**Consultation Response from KC,
Highways Development Management****2024/90279 adj, Parsonage House, Edge Road, Thornhill Edge, Dewsbury, WF12 0QD****Erection of detached dwelling****Date Responded: 2-7-2024.****Responding Officer: Mark Berry****Responding Ref: 16-22-3**

This application seeks approval to the erection of a detached dwelling at land adjacent to the Parsonage House, Edge Road, Thornhill Edge, Dewsbury.

PROPOSED NEW CONTEMPORARY HOUSE ADJACENT TO
 PARSONAGE HOUSE EDGE ROAD THORNHILL EDGE DGBURY
 WF12 0QR FOR MR. & MRS. S BROUGHAM MAY 2024

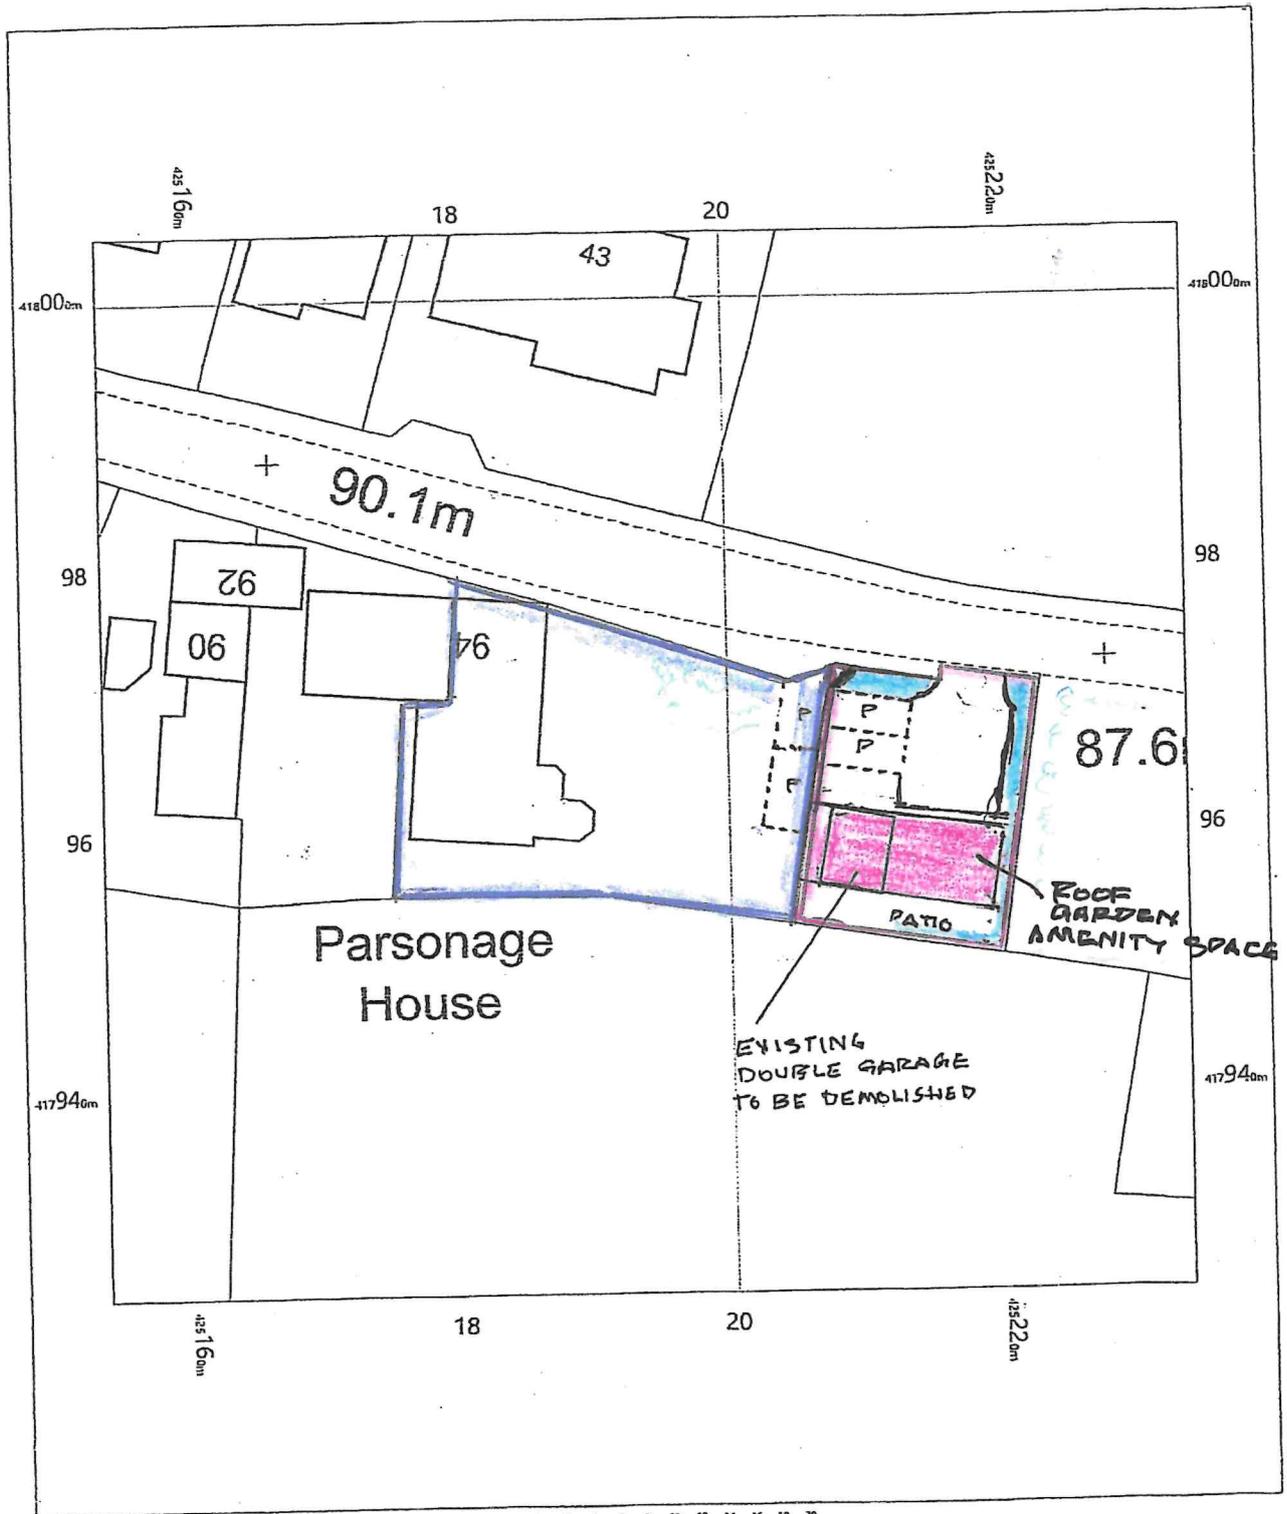
The proposals show a detached potentially 3 bed roomed dwelling within the existing garden to Parsonage House. The existing access on to Edge Road is shown to be utilised as access to the proposed dwelling. Two off-street parking spaces are shown to the new dwelling with internal vehicle turning.

Two new off-street parking spaces are shown to be provided to Parsonage House.

The plans provided are hand drawn and not dimensioned.

HDM would however recommend that the width of the proposed driveway is widened to 6.0m to allow comfortable turning and manoeuvre and bin collection points need to be provided for both the new and existing dwellings.

The proposed new off-street parking to Parsonage House is unacceptable. The proposed parking spaces are insufficient in length and sight lines onto Edge Road are poor.

Unless the applicants can provide revised proposals showing improved access and parking arrangements to Parsonage House this application should be refused on highway safety grounds.
